Reference Number: 6/2022/2300/COND

DESCRIPTION: Submission of details pursuant to condition numbers - 1 (Construction Management Plan), 5 (Surface Water Strategy), 6 (Surface Water Scheme), 7 (Drainage), 8 (Foundation), 9 (Design Plan), 10 (Accessible Housing Scheme), 11 (Highway Improvement), 12 (Samples), 13 (Hard Landscaping), 14 (Soft Landscaping), 15 (Hard landscaping - roof garden), 16 (external lighting), 17 (Cycle Store), 18 (Cycle Store under-croft/Open air), 19 (Balcony Screens), 20 (Energy & Sustainability Statement), 21 (PV Cells Plan), 22 (Bat & Bird Boxes), 23 (Noise Compliance), 24 (Noise Compliance), 26 - (SuDS), 27 (Access), 28 (EV Charging Points), 29 (Parking), 30 (Bin Stores), 31 (Roof Gardens), on planning permission 6/2020/3222/MAJ

LOCATION: Beadles Volkswagen Van Centre, Harpsfield Broadway, Hatfield, AL10 9TF

Thank you for notification of the above planning application. We are writing to object to the discharge of condition 8 of planning permission 6/2020/3222/MAJ.

BY: Author	DRAWING TITLE: PILE SETTING OUT GA
CHKD: Checker	
SCALE @ A0: As indicated	DRAWING NO: HAT-TAK-XX-FN-DR-S-0001
DATE: Jul22	DRAWING STATUS: CONSTRUCTION
	Rev: C1

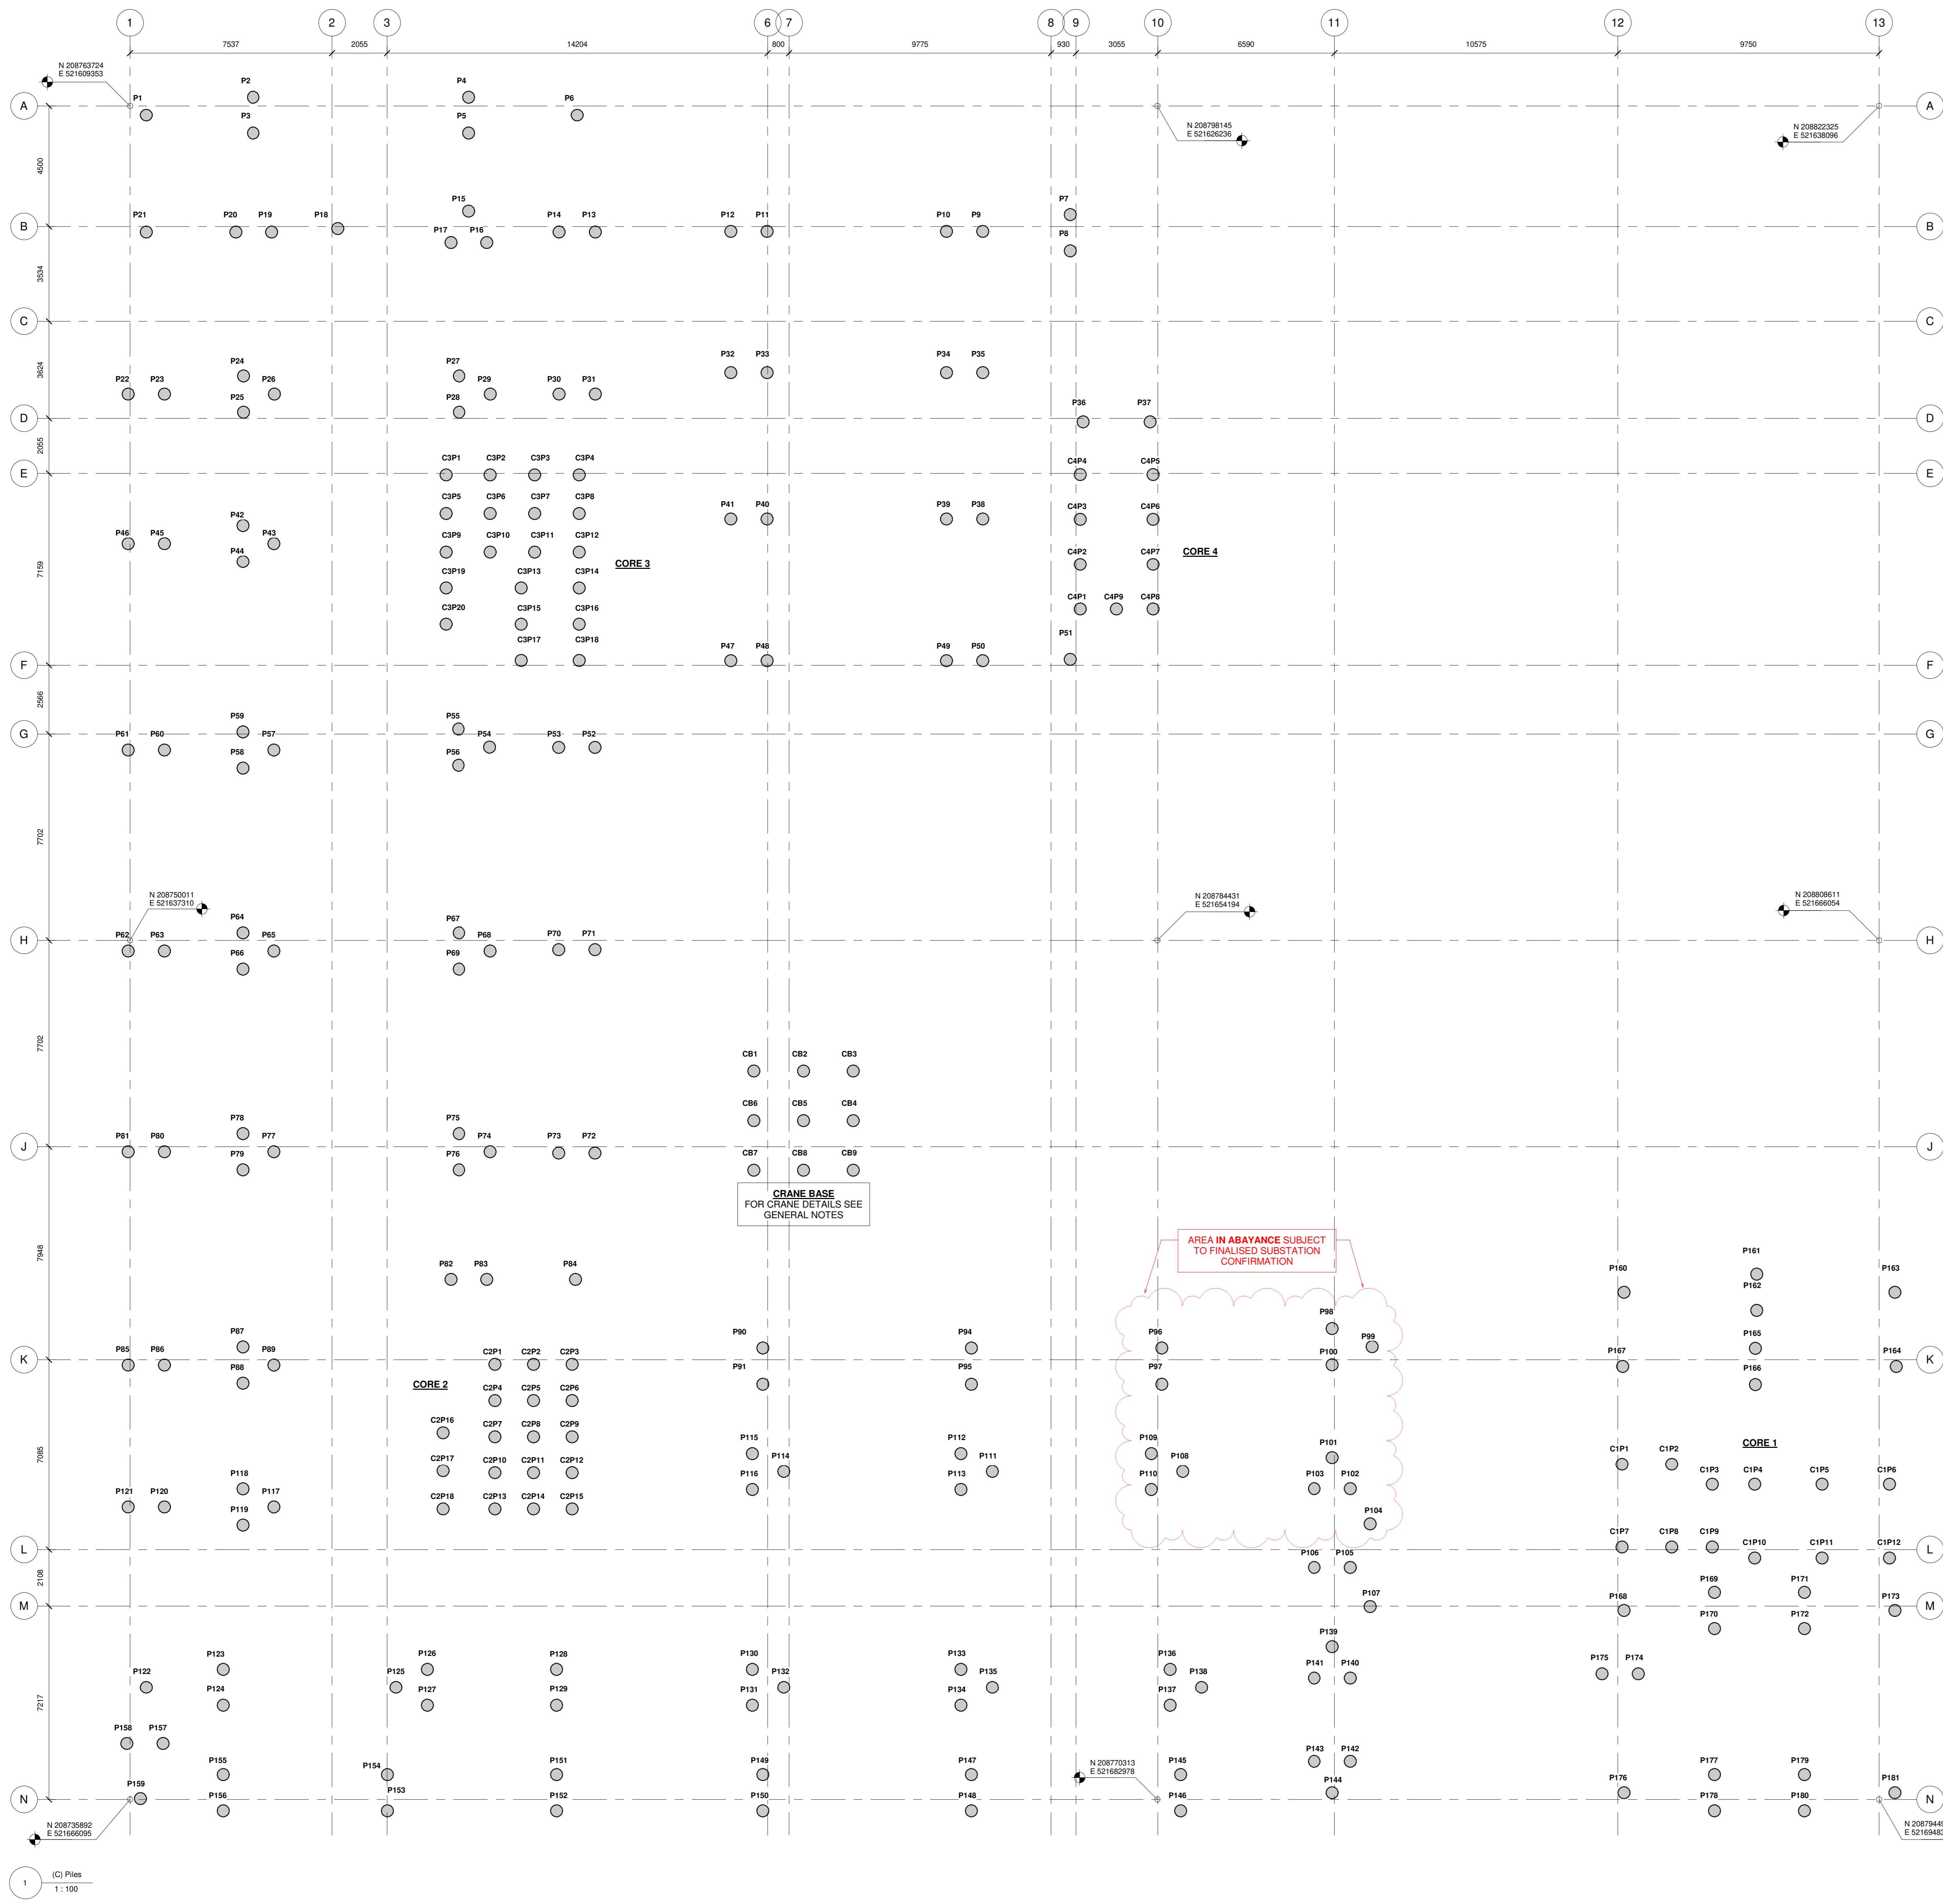
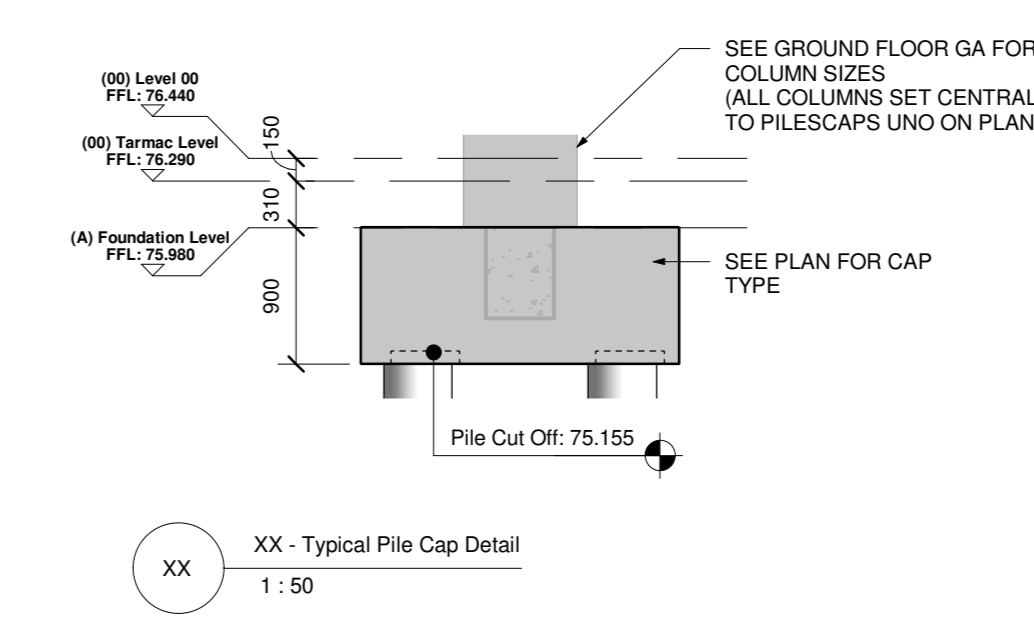
The proposed piling depth does not consider the risk of Bromate contamination to the Upper Gravels (Lowestoft Formation) and/or the diversion of the bromate plume present in the Lower Gravels/Chalk Formations.

Our concern is that the current proposed piling depth of 15.5m finishes at the base of the Clay and so, risks connecting hydraulically the Lower Gravels and Chalk to the Upper Gravels. This has a high risk of creating a pathway for upward migration of Bromate to the Upper Gravels. This represents a significant a pollution risk to third party sources, nearby surface water features, environmental systems linked to the Upper Gravels and bypassing active scavenging boreholes in the Chalk. Piling at this depth also has the potential to alter the flow direction in the Lower Gravels/Chalk, causing local diversion of the bromate plume which can undermine the scavenging activity undertaken by Affinity Water.

In order to consider removing our objection to condition 8, we would require that piling does not exceed a depth of 62mAOD (a minimum of 2m above the base of the Boulder Clay based on the limited information available from the two onsite borehole logs). We would expect that once the piling method statement has been updated, we would get the opportunity to review prior to discharging condition 8.
